From: Alison.Meeus@westsussex.gov.uk [mailto:Alison.Meeus@westsussex.gov.uk]
Sent: 14 May 2013 11:40
To: Planning.Responses
Cc: Francis.Oppler@westsussex.gov.uk
Subject: Re: Fw: Planning Consultation on: BR/41/13/

APPLICATION NO: BR/41/13/

Site Address: Land to the rear of Holmlea Town Cross Avenue Bognor Regis
PO21 2DN

Description of Works: Demolition of existing buildings and redevelopment of the site
with 6 No. two bedroom dwellings

6no two bedroom houses with 9no parking spaces

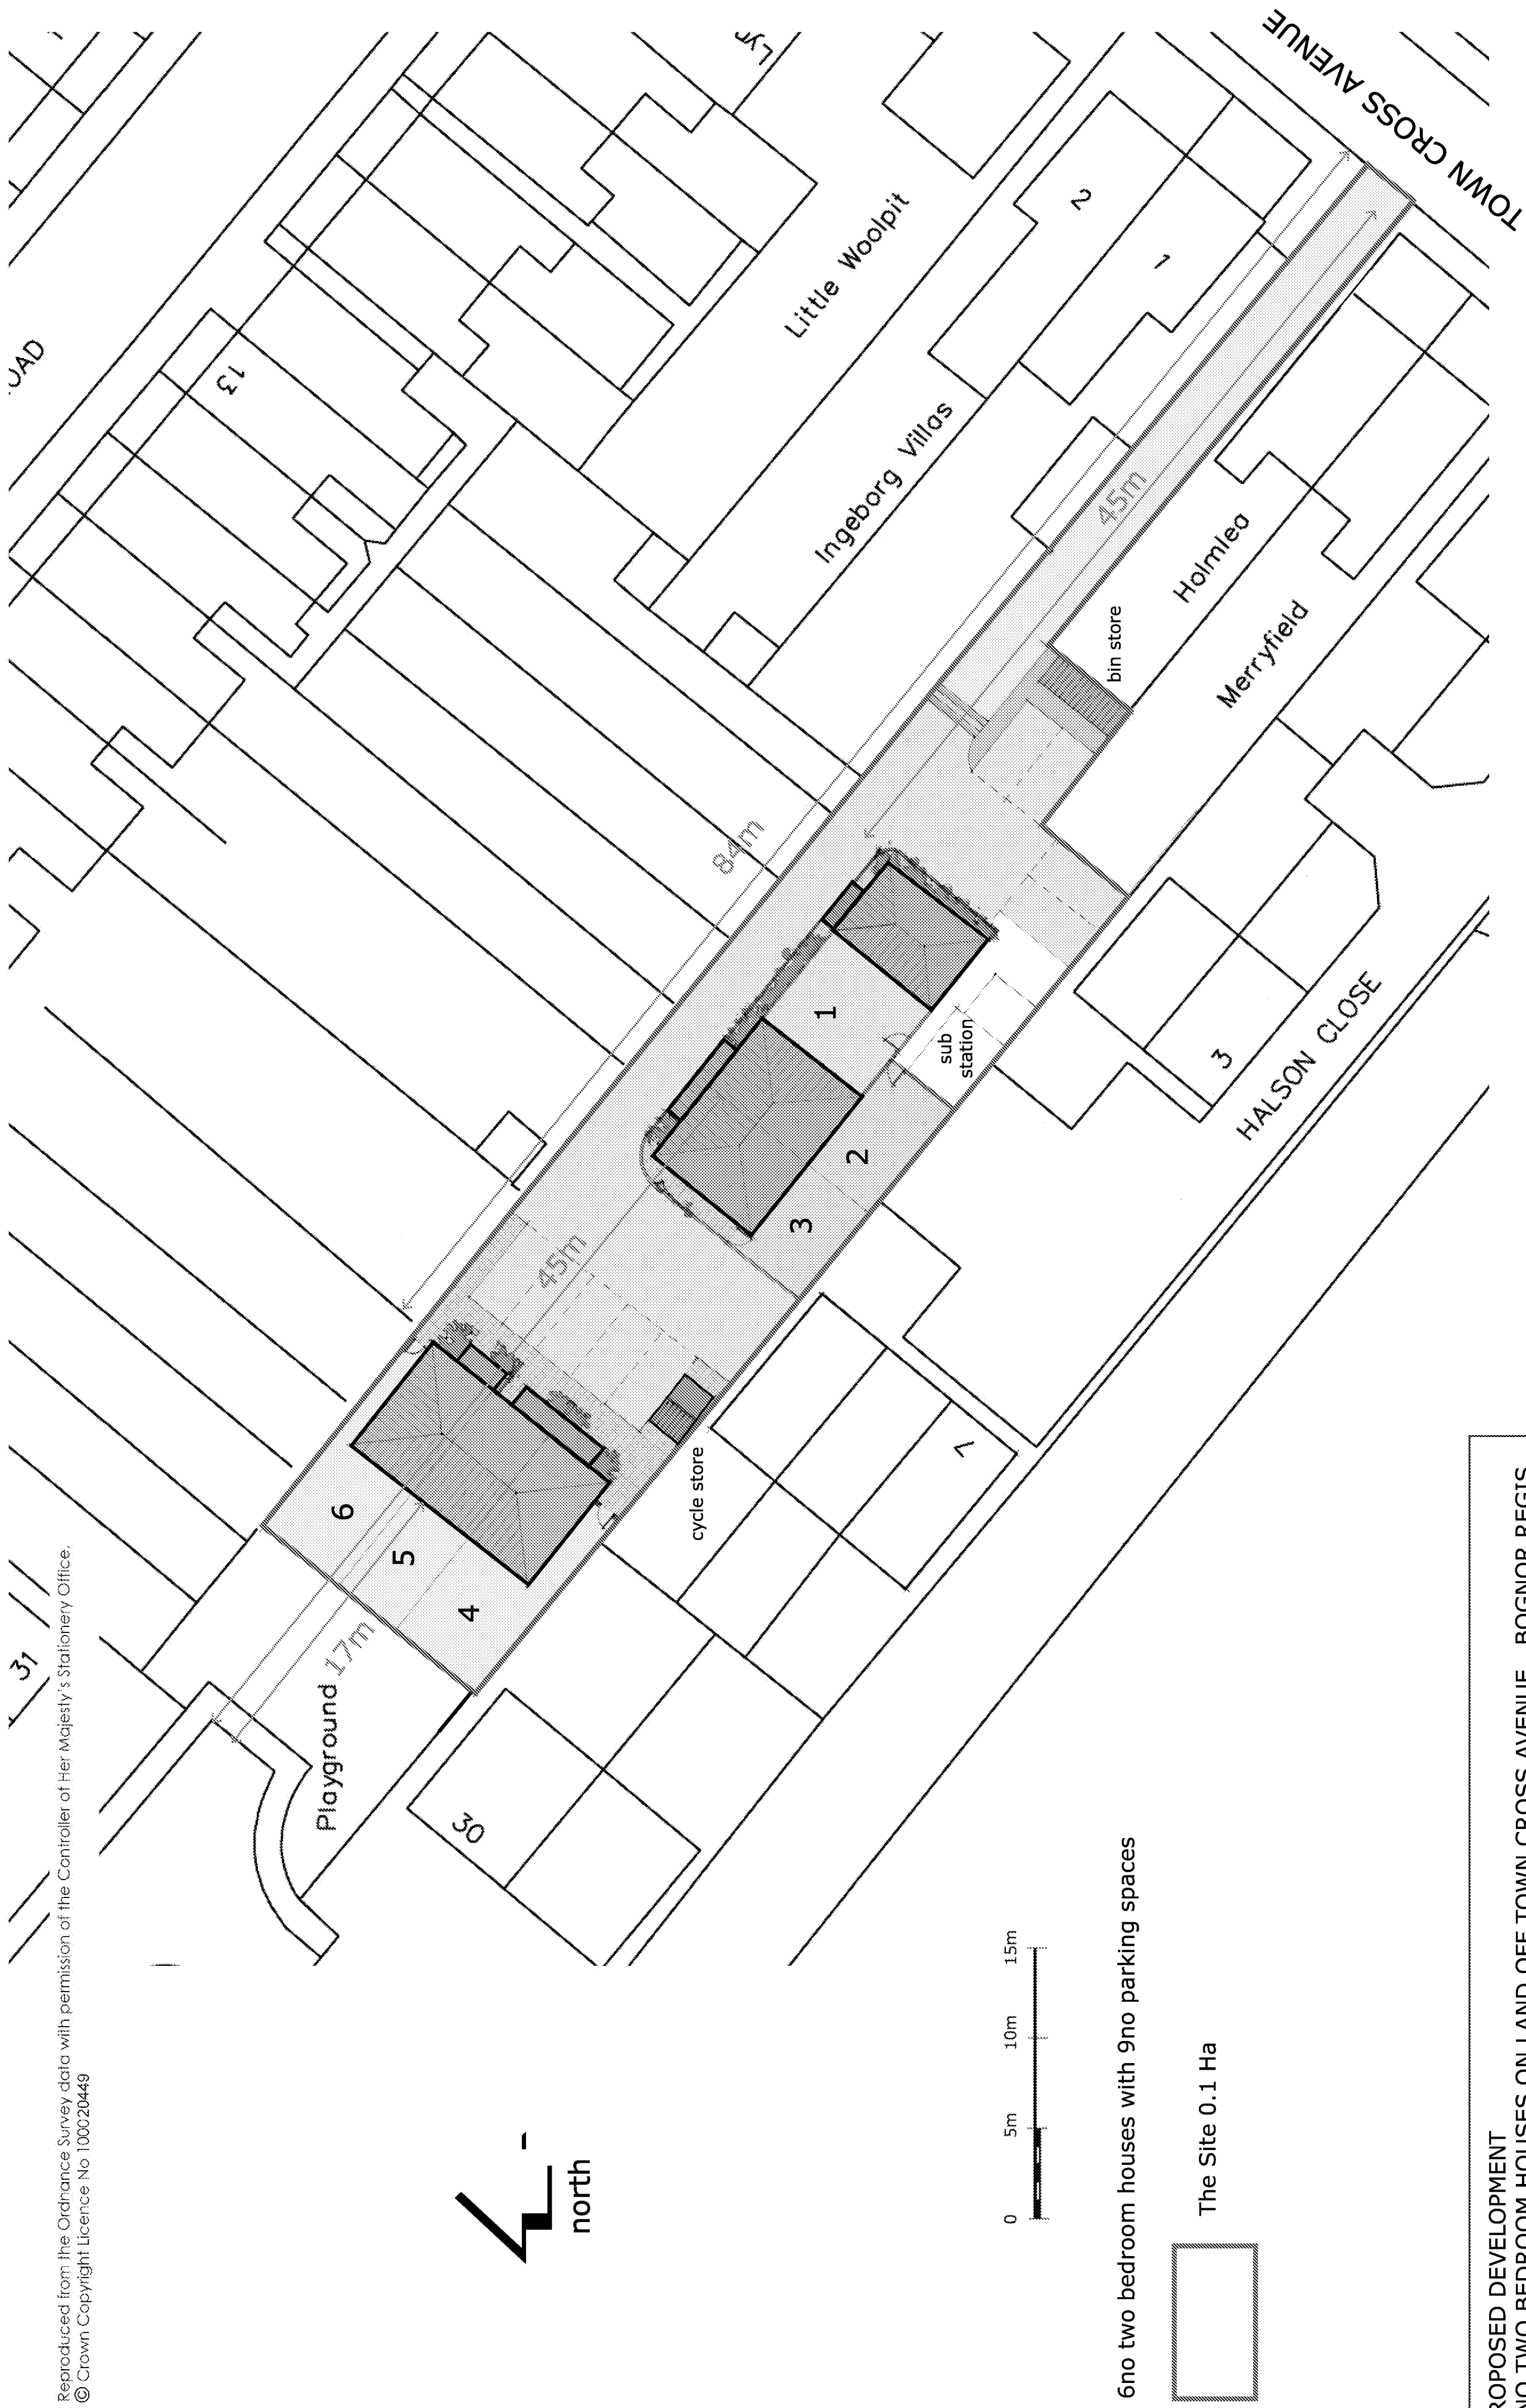
- 1) Although the proposed access is existing, and the number of trips generated from 6 dwellings is unlikely to have any material impact on the highway. WSSC would like to know what visibility splays are achievable from this access onto the highway. The design and access statement indicates that the visibility splays will be within the applicants control. These should be set back 2.4m from the centre of the carriage way (2m minimum) and drawn to the nearside kerb in both directions.

- 2) The width of the access road has not been indicated and as a guess it appears to be too narrow or only just within guidance. We need clarification to make sure a fire appliance can enter and turn within the site in the event of a fire.

- 3) Please provide swept path diagrams showing how a fire appliance will move within the site. We need to know the appliance can enter the access road from the highway as well as being able to turn within the site without over running the existing kerblines. Guidance from the Fire and Rescue service act 2004 states:

Cul-de-sacs - turning facilities should be provided on cul-de-sac roads exceeding 20m in length. This can be a hammerhead or turning circle designed on a minimum road width of 3.1m. This turning facility should be provided within 20m of the end of the access road so that fire service vehicles do not have to reverse more than 20m.

- 4) Please provide evidence of where bicycles will be stored that is secure and covered. This development would require 1 space per dwelling.
- 5) WSSC car parking calculator indicates that for 6 x 2 bed houses we would expect there to be a parking demand for 9 cars. Therefore the current number of carparking spaces associated with the development is accepted by WSSC.
